PLANNING CONSULTATION RESPONSE

Application No	2026/0599 & 0600
Proposal	2026 0599 & 0600 Subdivision and C of U for Office and Laundrette with Four Studio Apartments and Assoc Internal Alterations with Revised Access Frontage Arrangements (Retrospective) 8 Regent Street
Address	8 Regent Street Barnsley
Date of Consultation Reply	050826
Consultee	Tony Wiles Senior Conservation Officer

Proposed First Floor Plan
scale 1:50

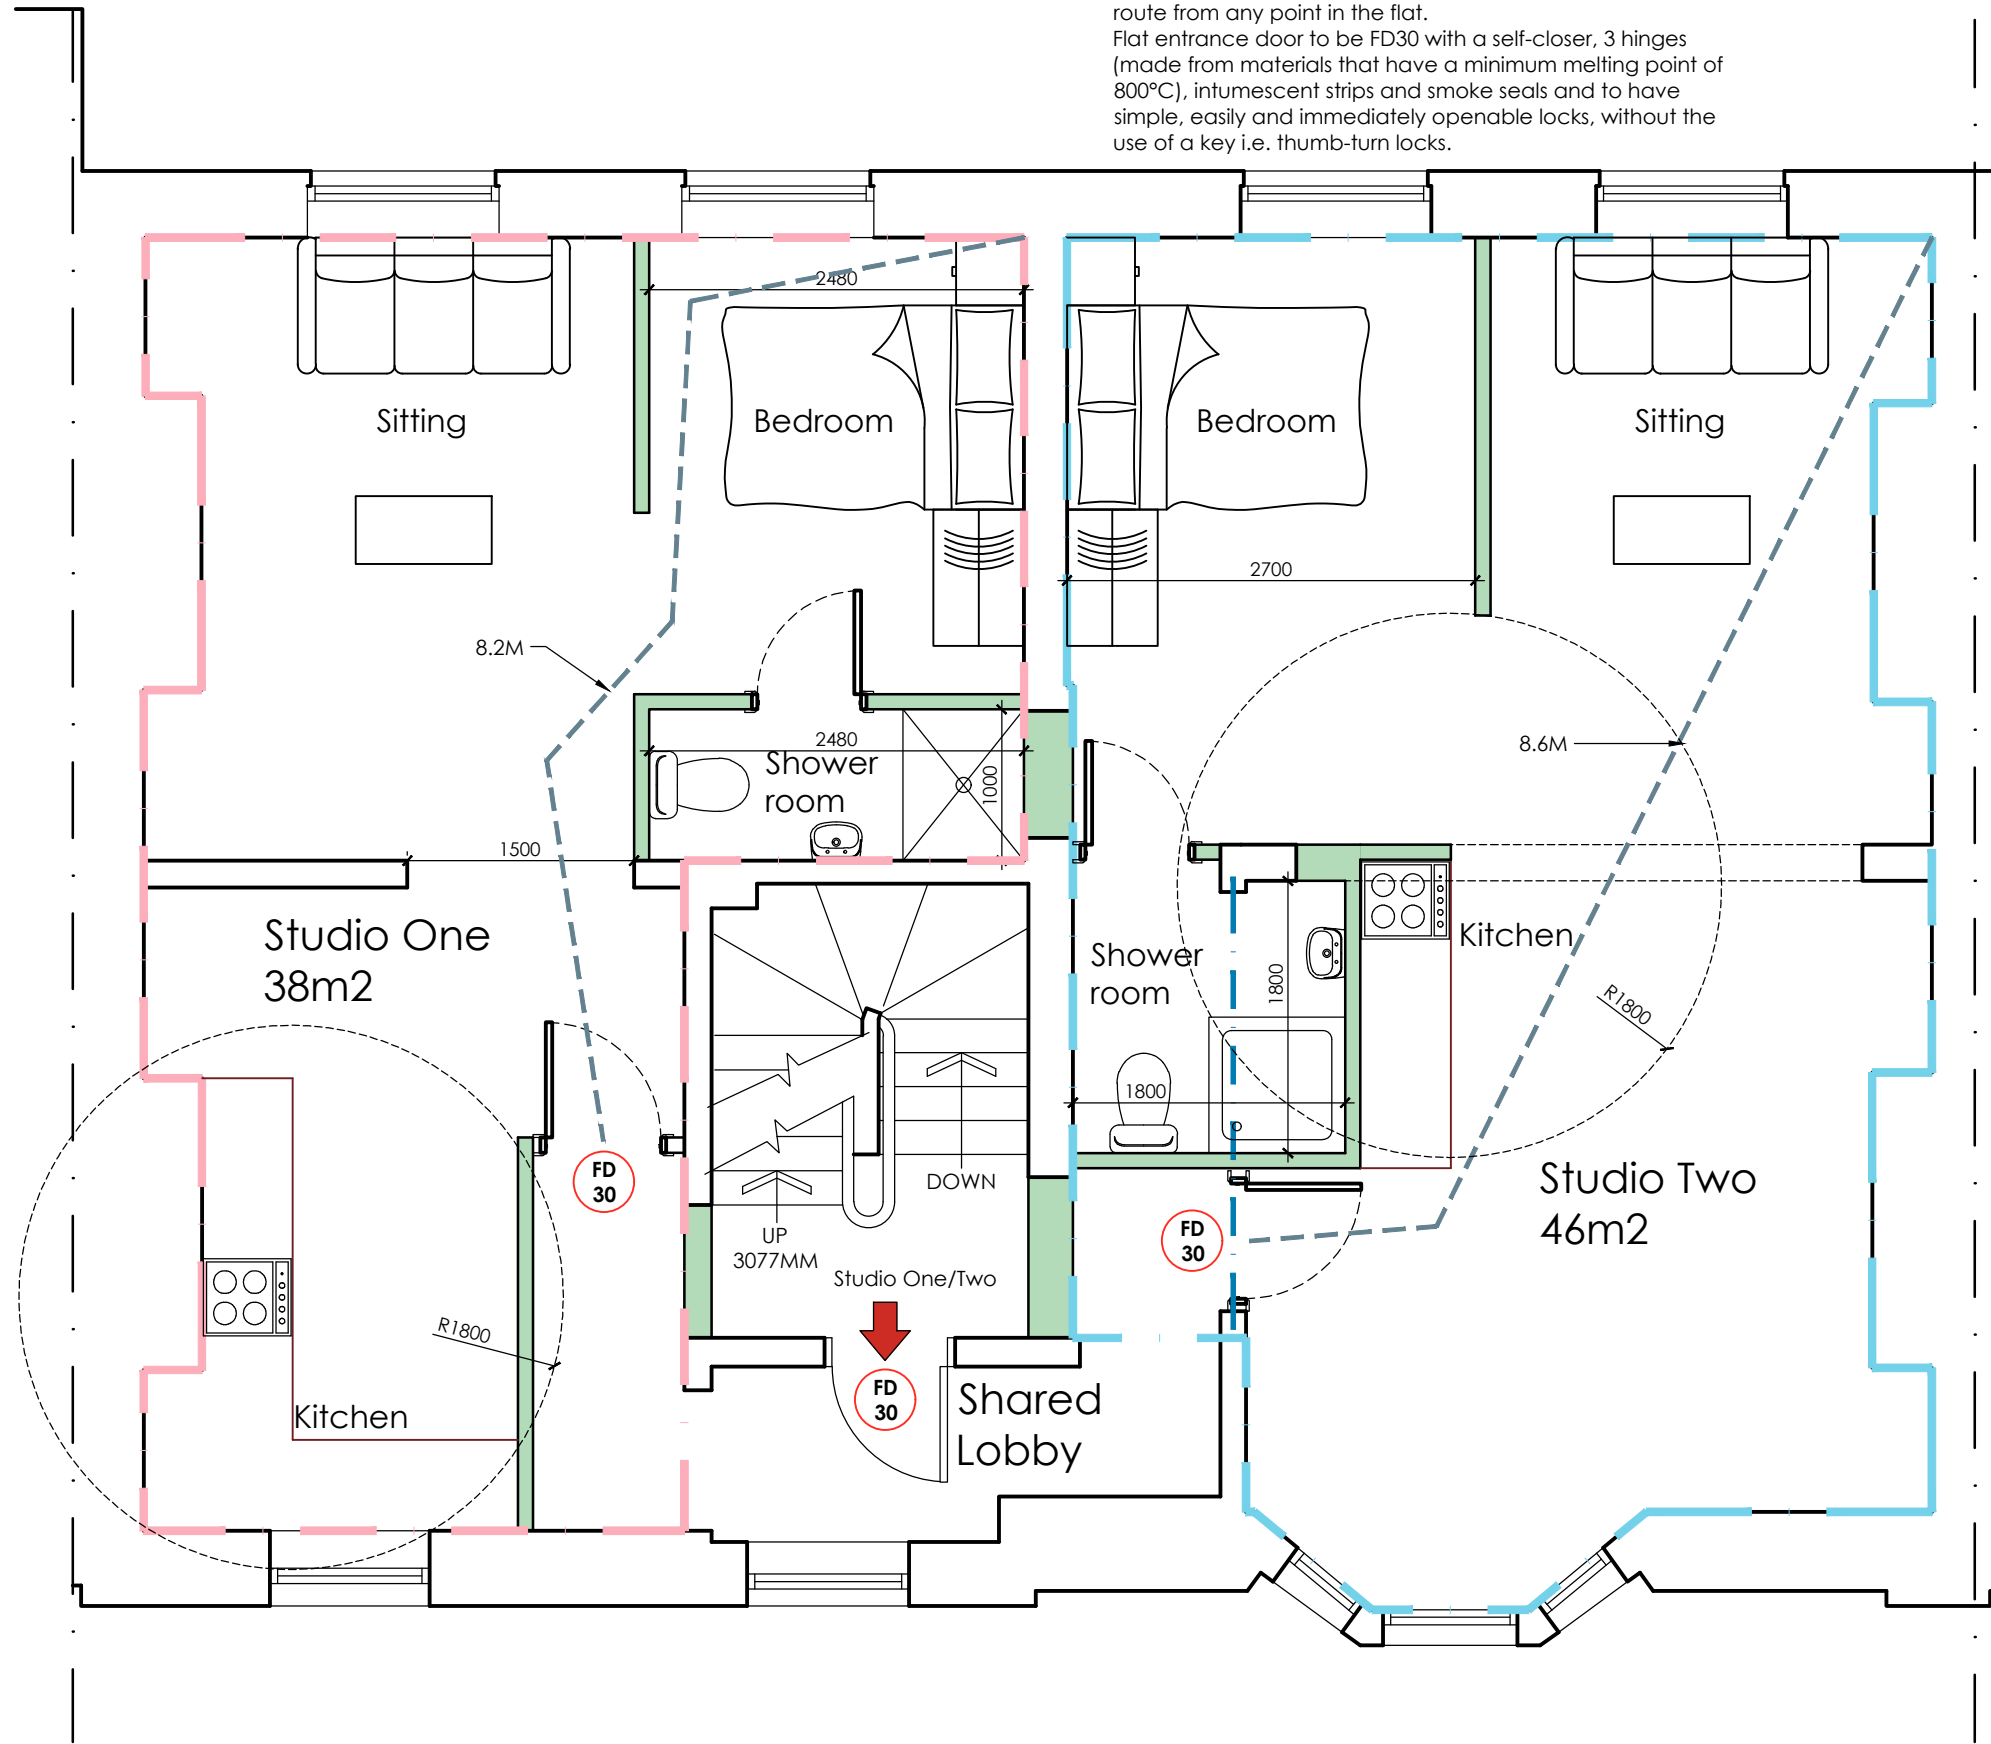
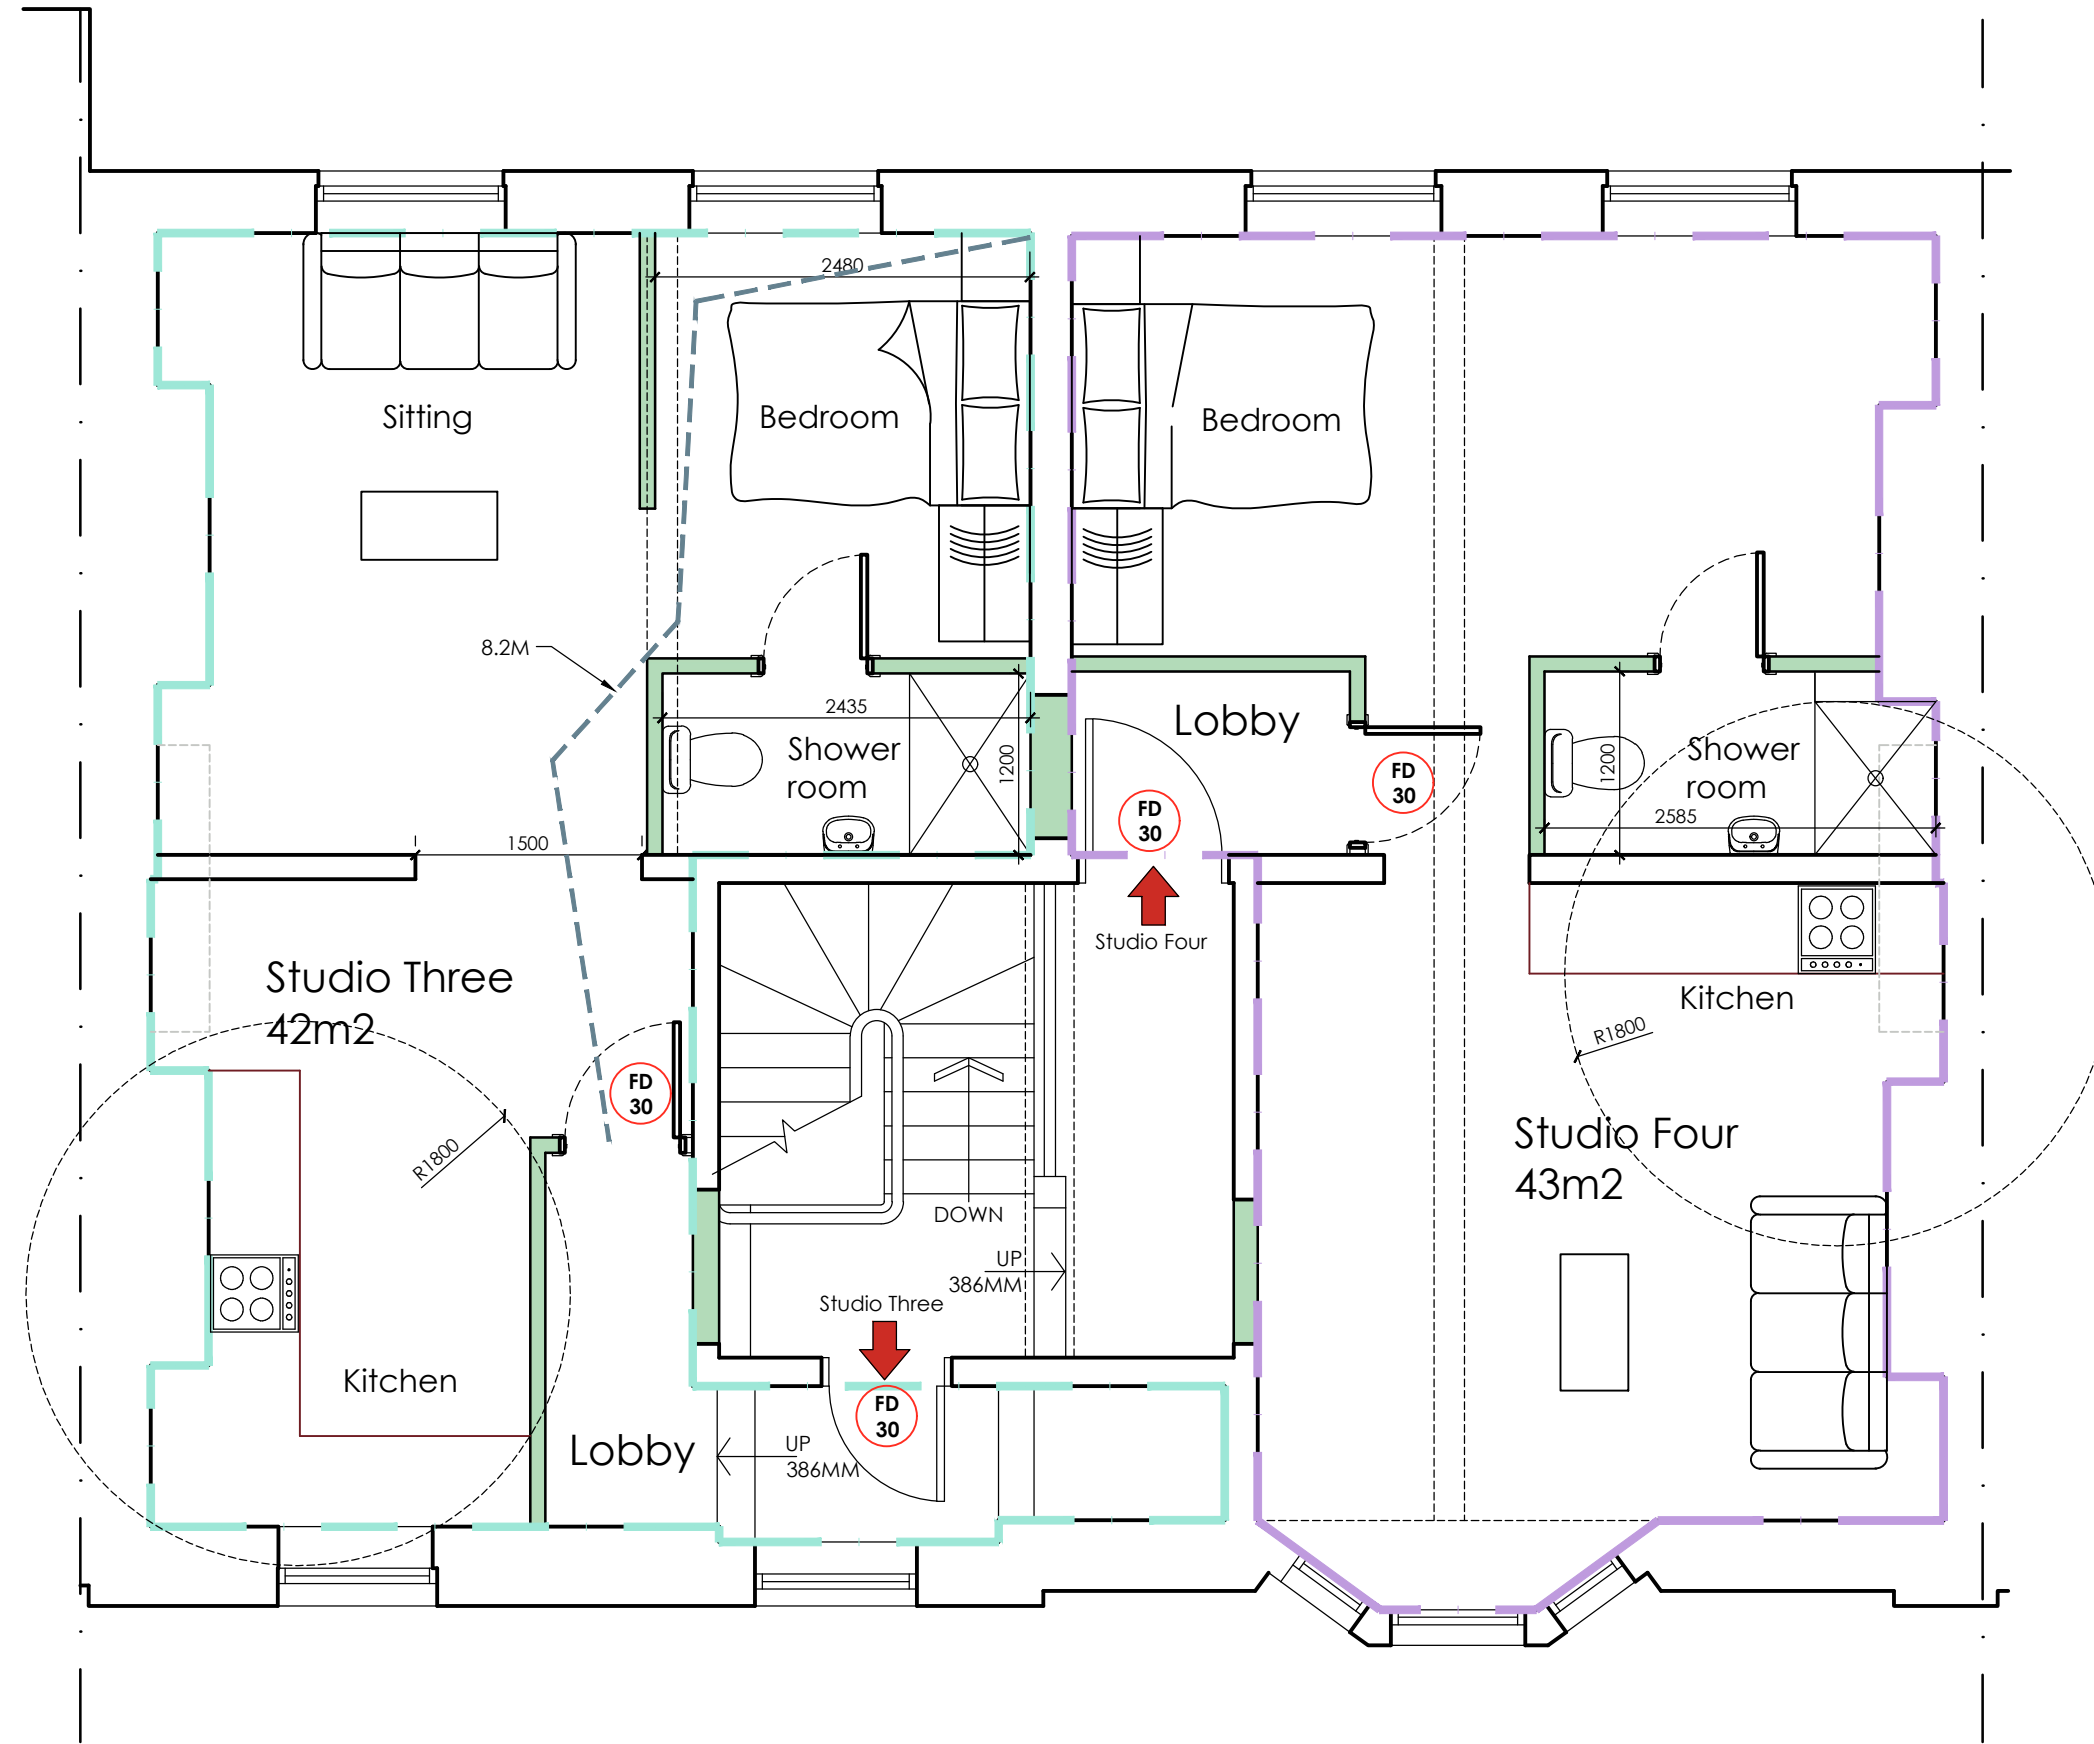
No external works or basement-level alterations are proposed. The applicant states that no significant historic features are proposed to be removed, with the works principally comprising internal subdivision, fire and acoustic separation, and alterations to form the office and laundrette lobbies, residential entrance, and four studio apartments. Minor frontage and access alterations were originally proposed, but the submitted plans have now been updated to omit these. At ground floor level, two lightweight stud lobbies would be formed either side of the entrance hall after entering through the front door, providing independent access and, I presume, fire separation. To the rear of the building, a communal bin store would be created. A similar bin store arrangement was approved in 2024. At first and second floor levels, the existing stairwell access to the side offices would be blocked up and replaced with a shared lobby at the front of the building on both floors. These lobby areas would be formed within spaces currently occupied by W.C.s at first and second floor levels. Elsewhere, the studio flats would be created by closing off the existing interconnecting doorways which currently allow access across the floors, together with further lightweight stud partitions to provide toilet and shower rooms. Each flat would be arranged in a generally open-plan manner. Overall, the internal interventions are relatively light-touch and appear largely to affect modern fabric or later alterations which do not make a strong or positive contribution to the historic significance of the listed building. On that basis, I support the principle of the proposal; however, there are some matters which require clarification or amendment. I note the proposed removal of the structural wall at first floor level between Studio 2 and the shared lobby. This appears to be an original structural wall, and its removal would be a more intrusive intervention. It would introduce a minor degree of harm to the historic fabric and would erode the original plan form and layout. I would therefore suggest that the scheme is amended to avoid this intervention, or that a clear and convincing justification is provided to explain why it is necessary, beyond the general requirements of the conversion to apartments. I also note the proposed removal of the dividing wall between existing office rooms 5 and 6 to create the open-plan space for Studio 2. It is not clear from the information provided whether this is a stud partition, a later subdivision, or historic fabric, and this point requires clarification. I also anticipate that the conversion of the ground-floor unit to a laundrette will require signage. While I do not object in principle to the change of use of the space, any signage will need to be restrained, compatible with the quality and character of the listed building, and accommodated within the constraints of its architecture, as set out in the informative below. Finally, while the plans do not appear to indicate its removal, I would ask for confirmation that the three-centred downstand and moulded arch, together with the adjacent guardrail, newel post and balusters at the head of the second-floor stair, will be retained as existing.
